**Consultation Response from KC,
Highways Development Management**

2025/91184 land off, Bretton Street, Savile Town, Dewsbury, WF12 9BZ

REVISED AND ADDITIONAL INFORMATION RECEIVED: Erection of two storey industrial unit (Use Class E(g)(iii)), with associated car park, service area and other associated works

Date Responded: 1st April 2026

**Drawing 165629-001 – Vehicle Swept Path Analysis for Refuse Vehicle**  
**Drawing 165629-002 - Vehicle Swept Path Analysis for 16.5m articulated Vehicle**

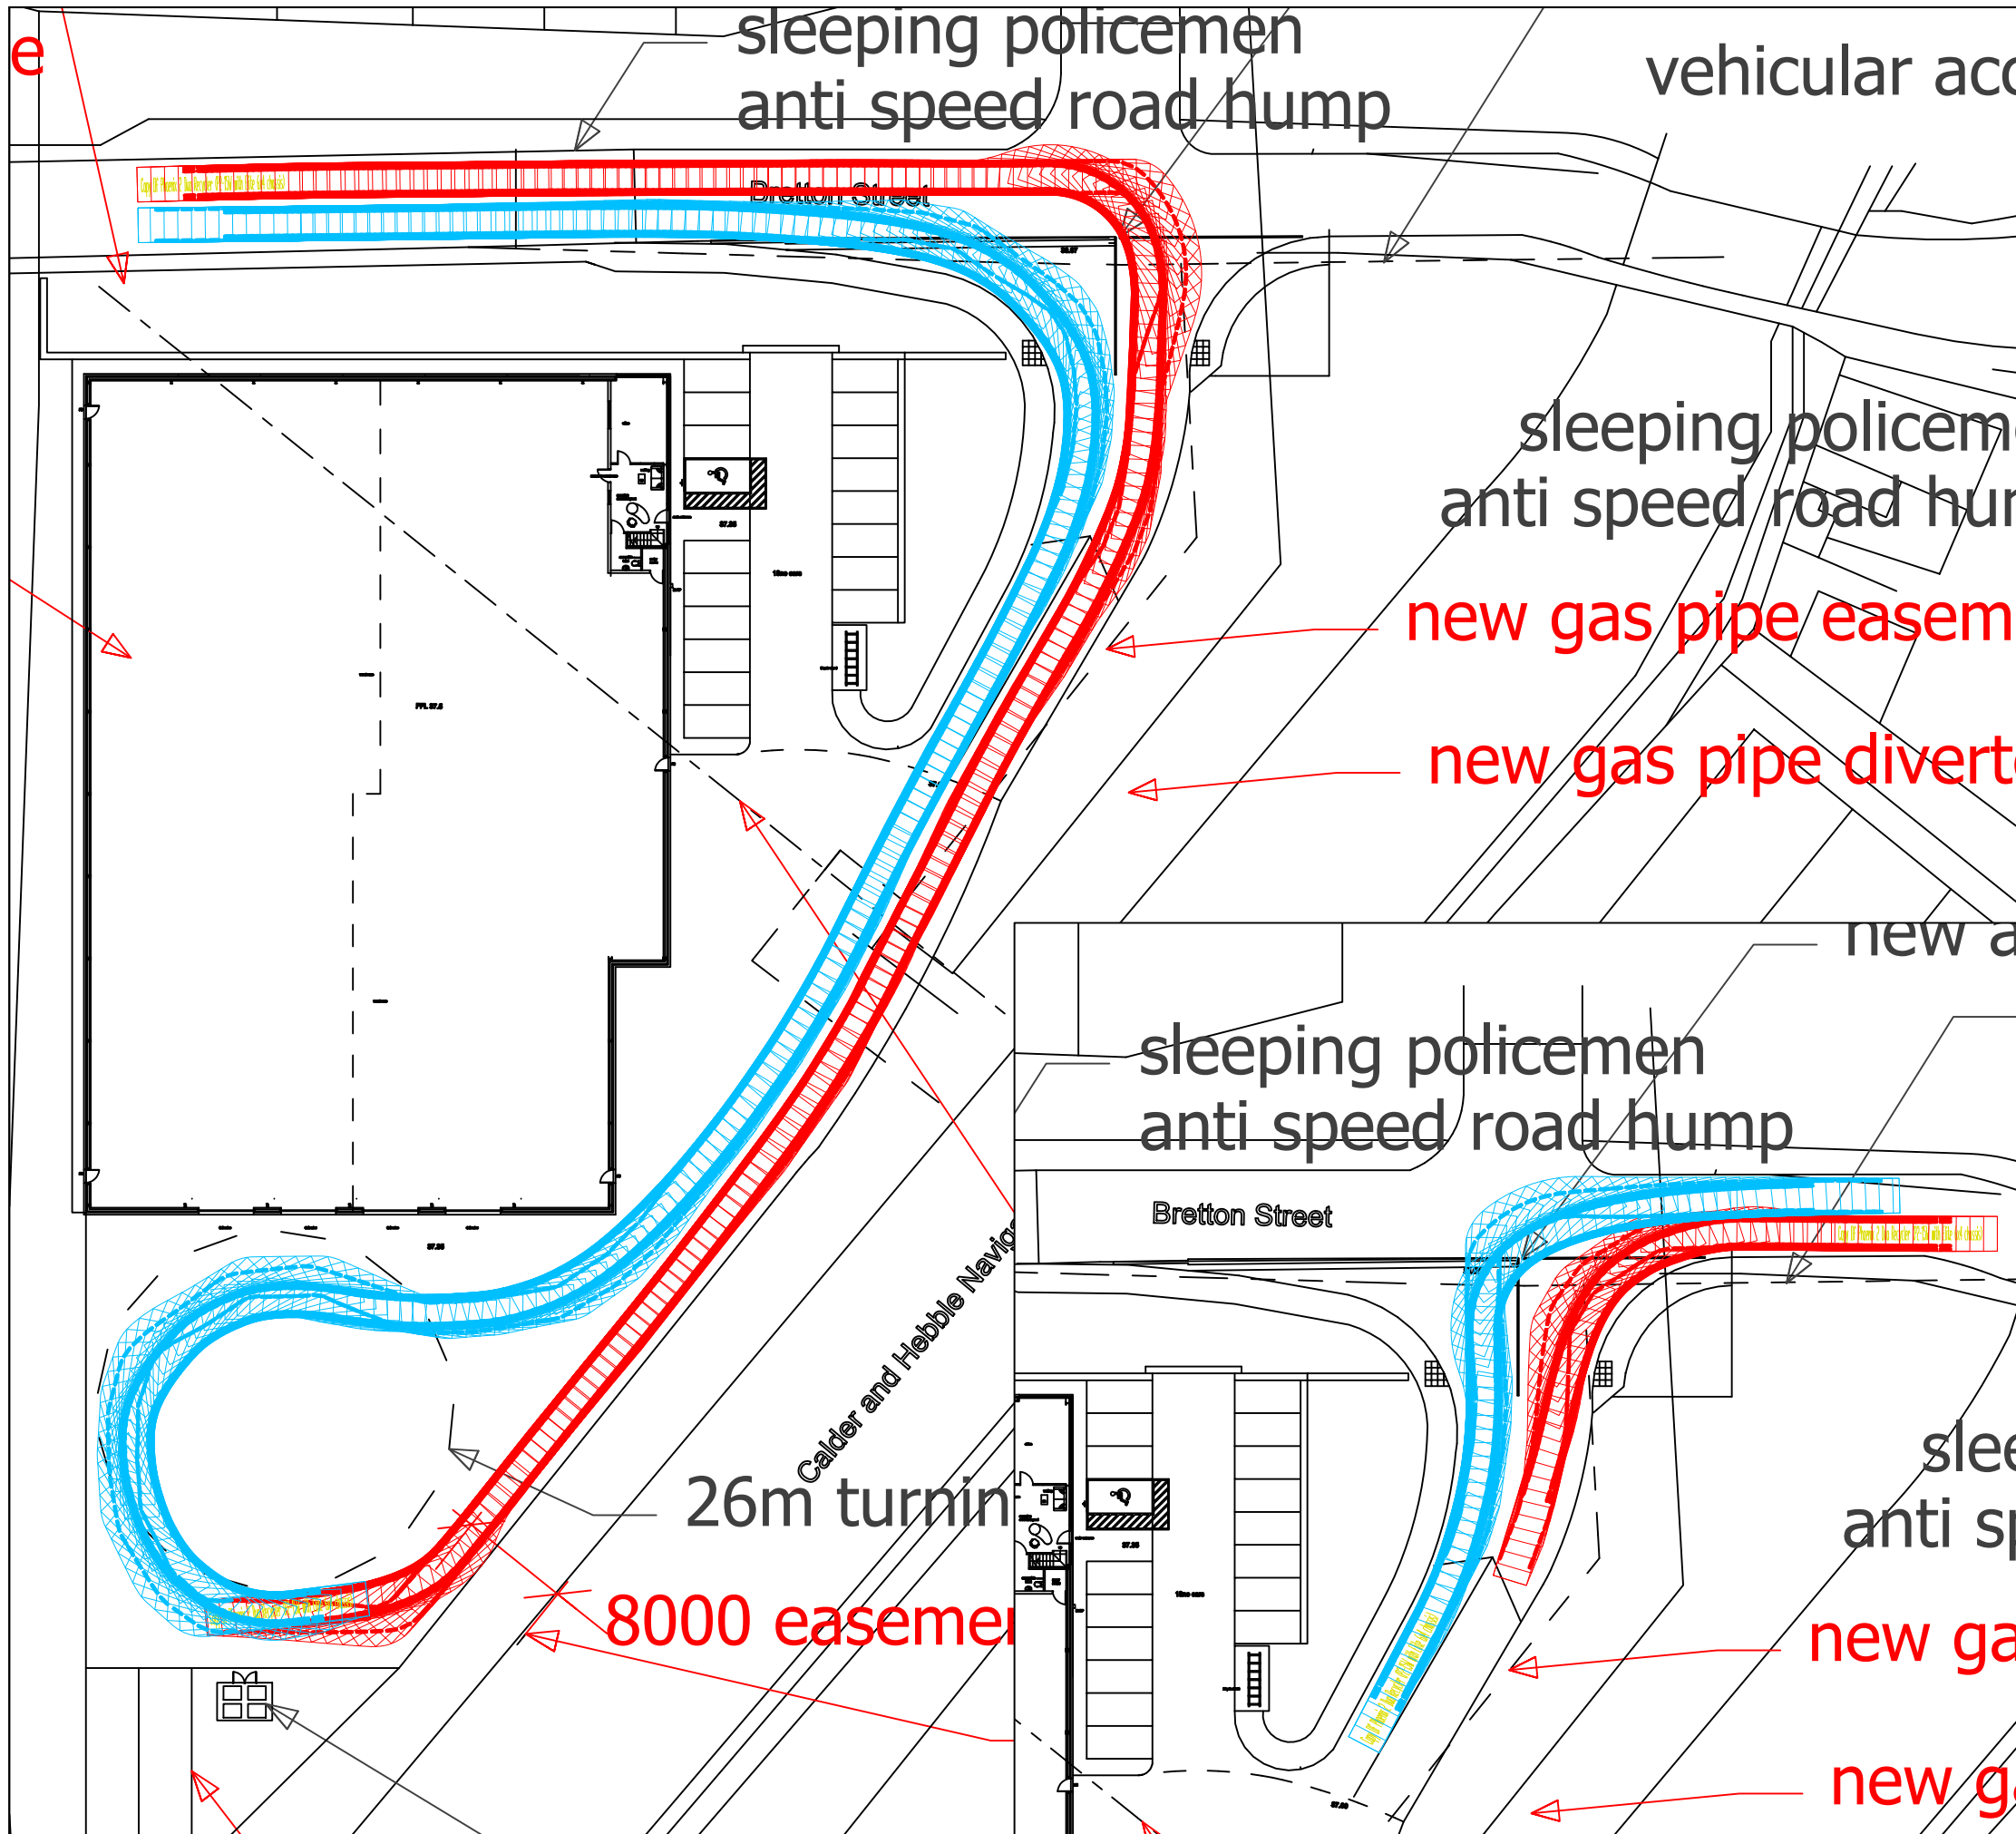
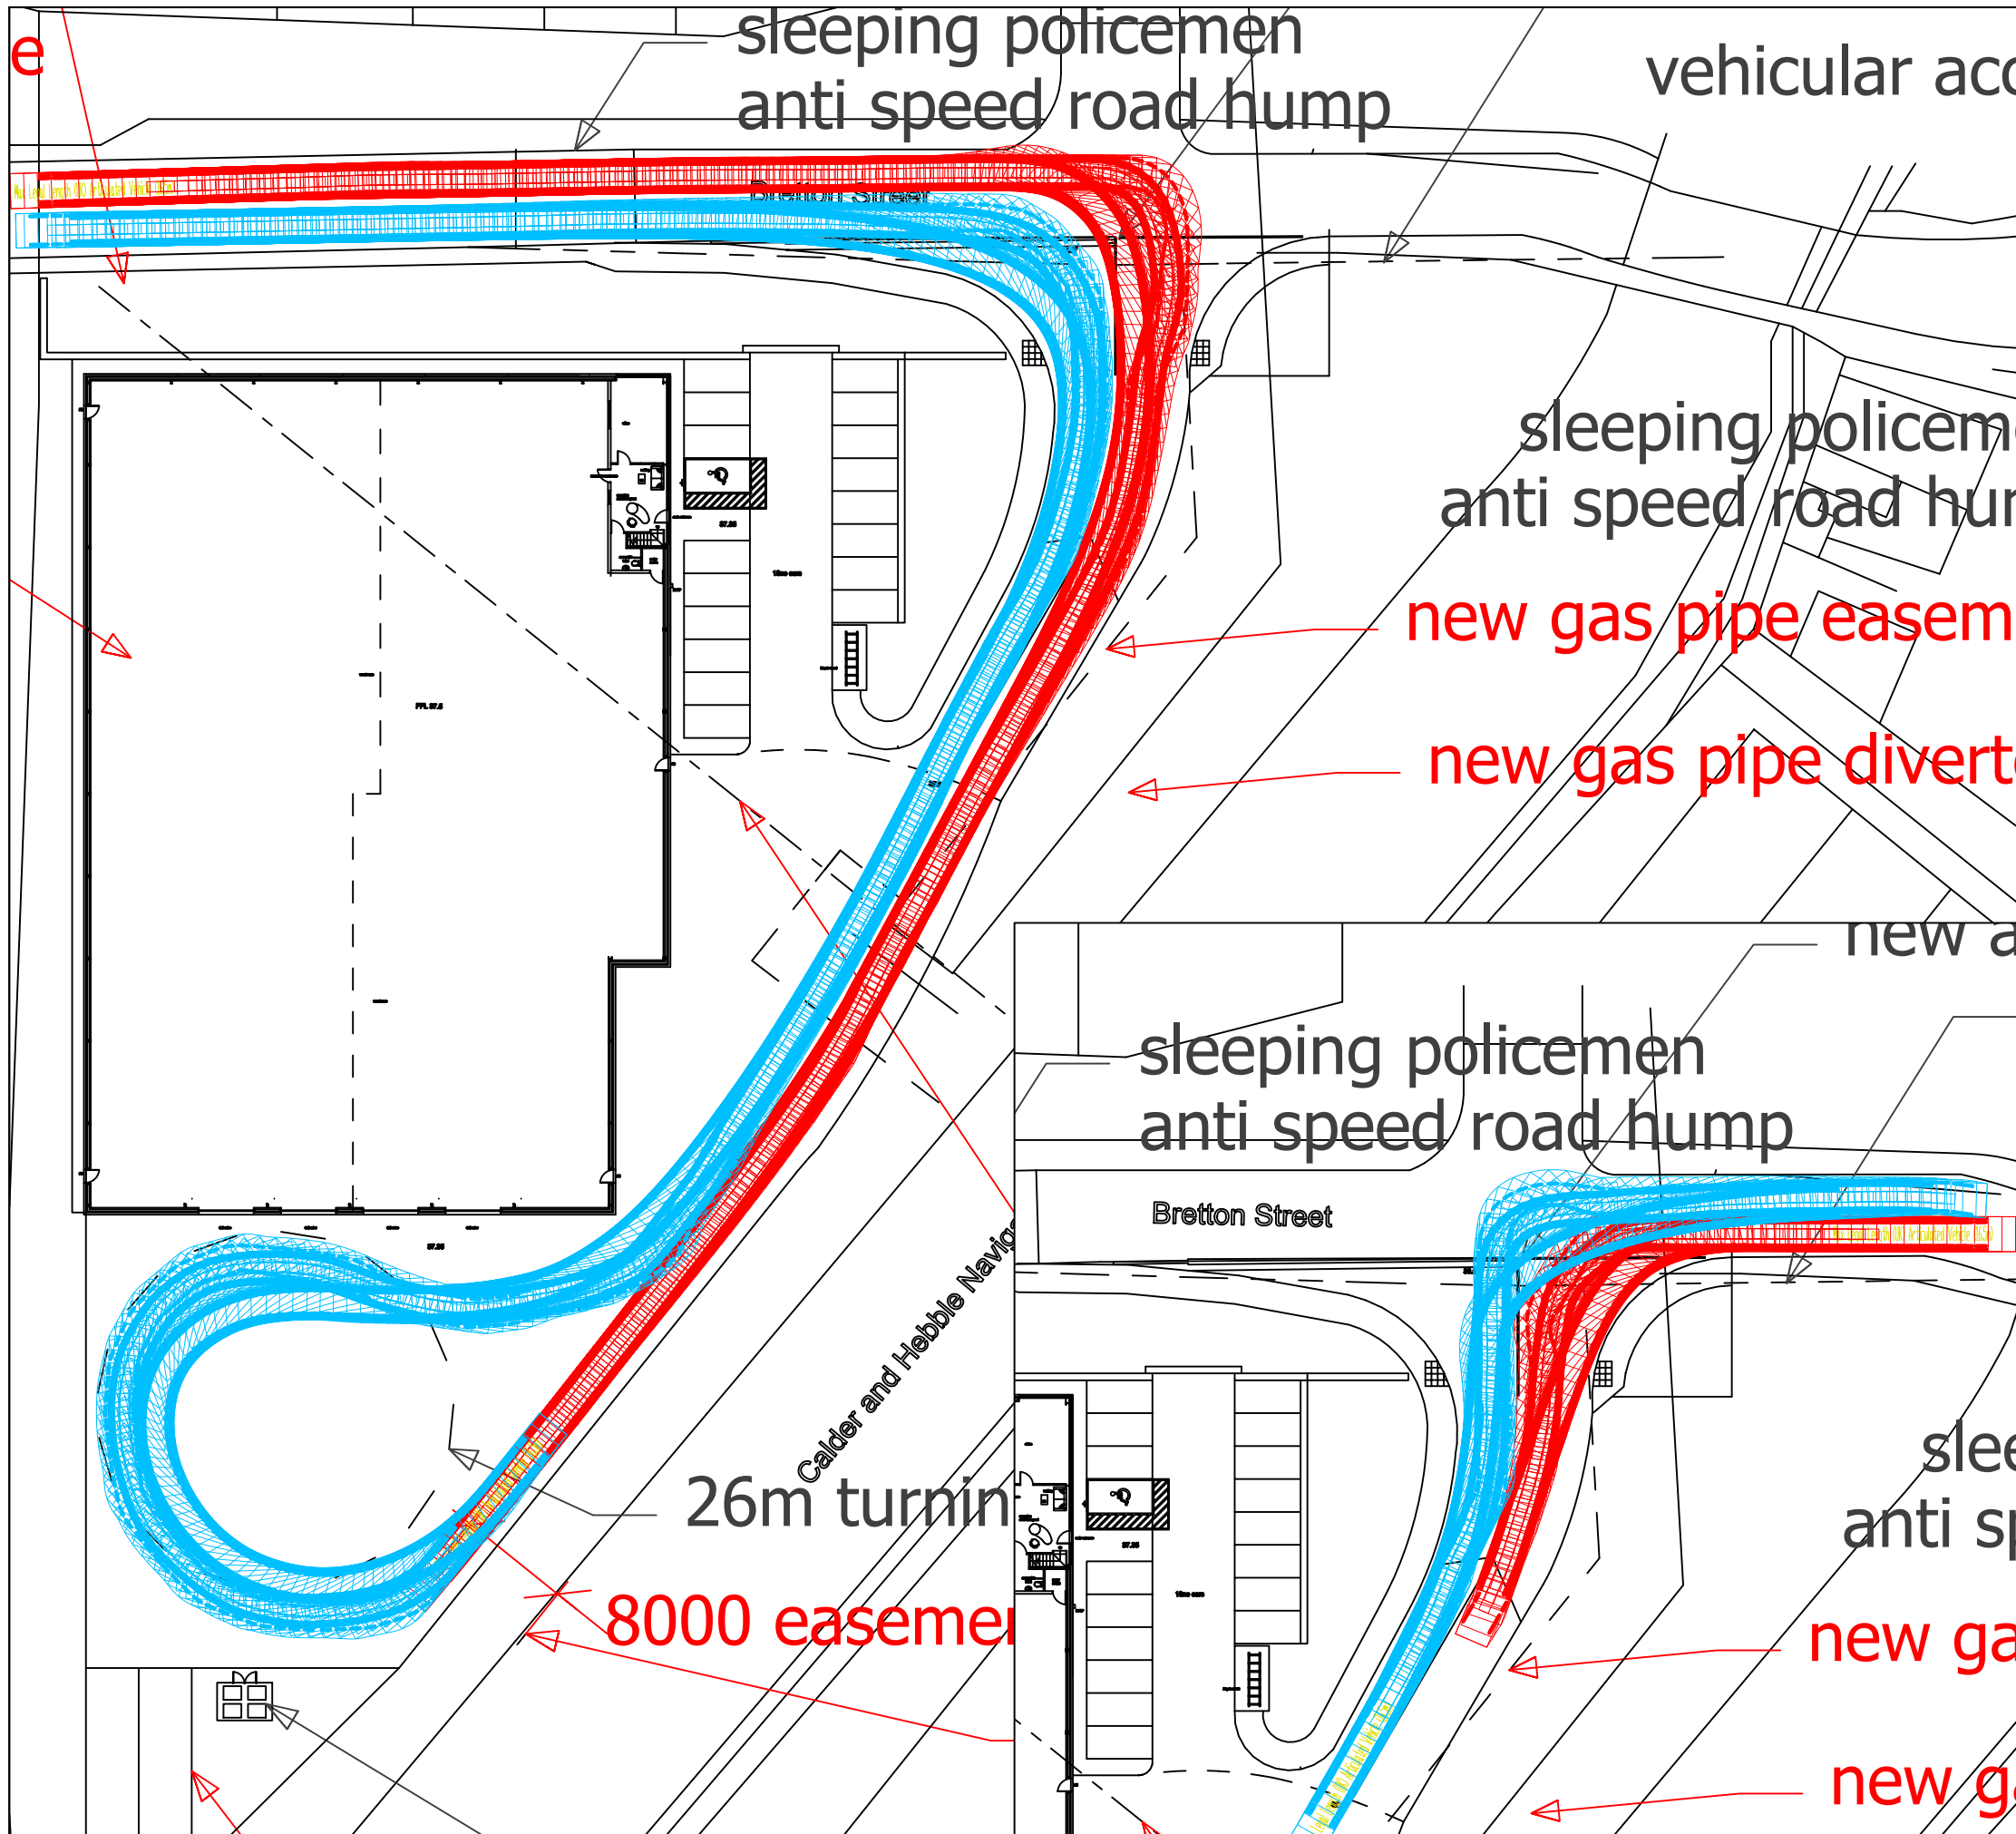
In addition to the previous comments, following a review of the Vehicle Swept Path Analysis plans, Appendix D of the Transport Statement, it is observed that vehicles using the loading docks on the southern elevation of the building would extend into and obstruct the service vehicle turning area. Demonstrate how loading/unloading and vehicle turning can be accommodated.
